**Case reference:** TR010056

**Document reference:** GWT response to ExQ2 – Deadline 6

Table 1D6	Gloucestershire Wildlife Trust responses to Examiners Questions Ex2, submitted at deadline 6		
ExQ2	Question to	Question	GWT response at deadline 5

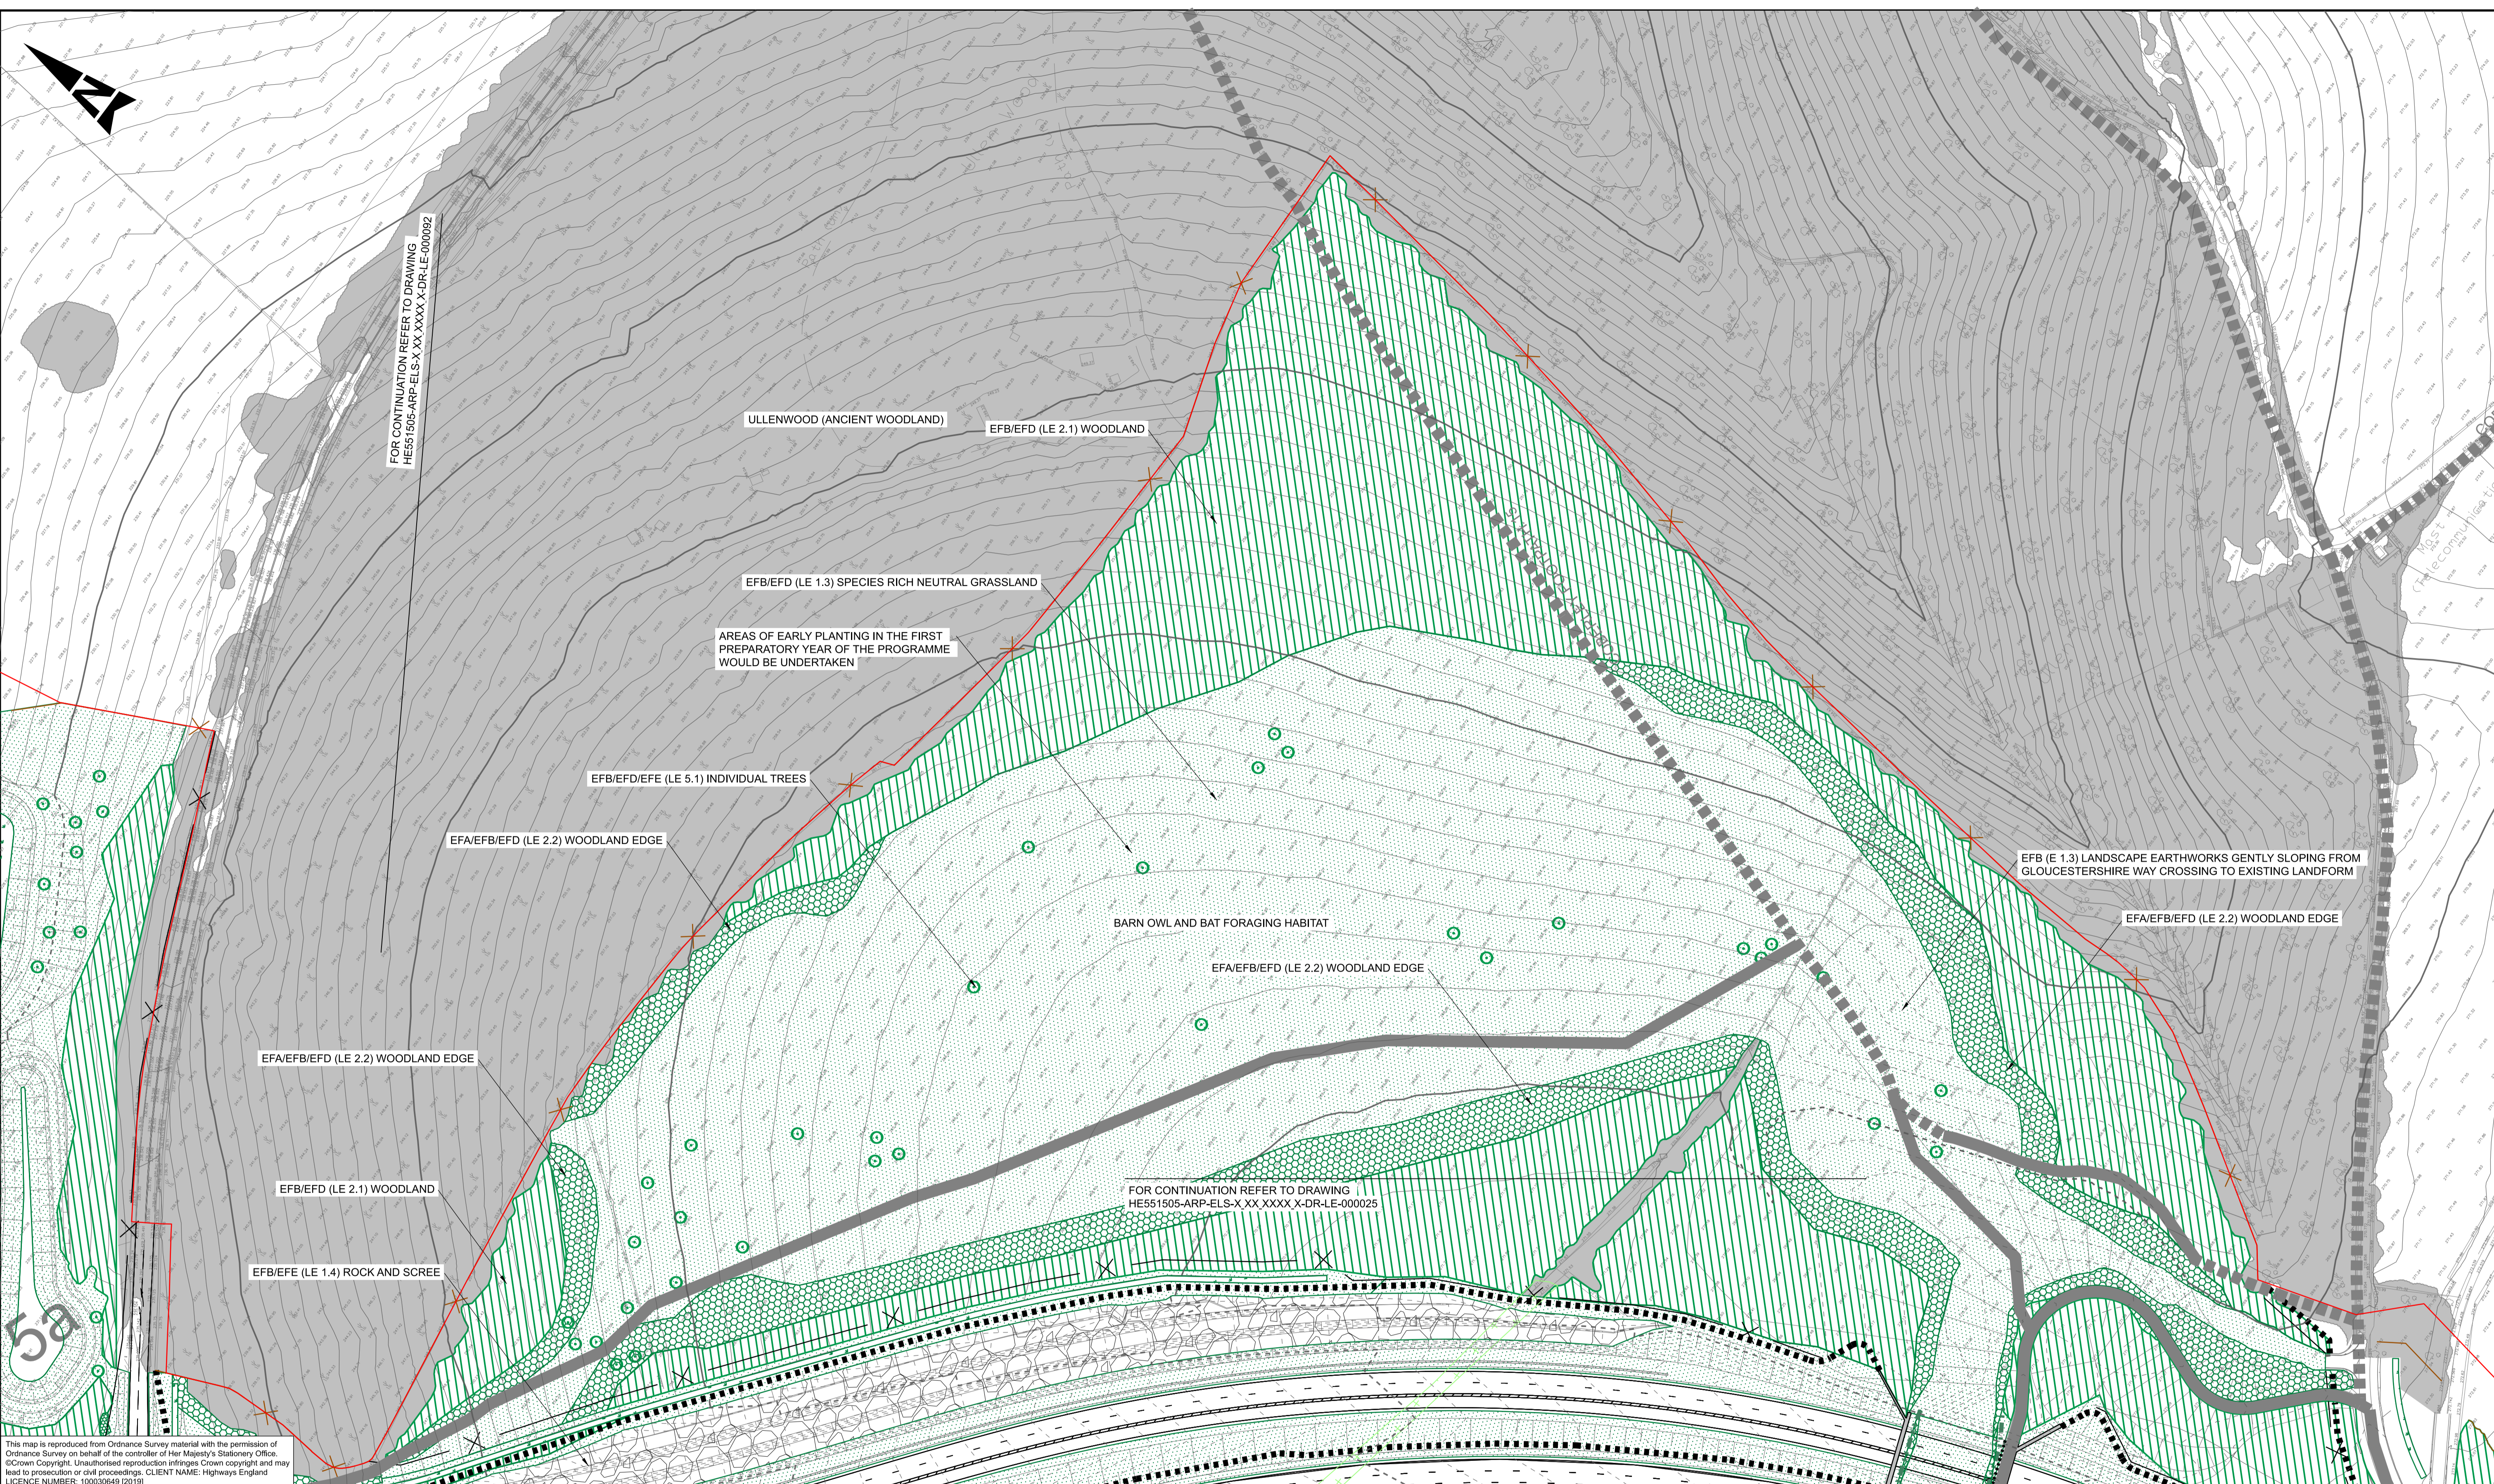
2.4.6	Joint Councils	<p>Ullenwood Cricket Club</p> <p>a) With reference to the Statement of Common Ground and the apparent acceptance by GCC of land being acquired by the Applicant, have any comments been received from the Cricket Club?</p> <p>b) Would the recreational facility be unavailable at any time to the club or the public during the construction phase of the development?</p>	<p>The Ullenwood Cricket Club pitch is on land owned by GWT. Responses to the questions asked are below.</p> <p>a) GWT has repeatedly sent communications to the cricket club on various matters since 2017, including the A417 proposals. Several communication attempts have been made in the last year and during the examination period. Very few responses have been received and there have been no comments regarding land acquisitions affecting the cricket pitch.</p> <p>b) GWT's understanding is that the club's primary pitch is now in a different location and the Ullenwood pitch has had little use in recent years. Due to a combination of this and other reasons, GWT has decided to take the pitch back in hand and this land will now be used for biodiversity enhancement and to support school visits.</p>
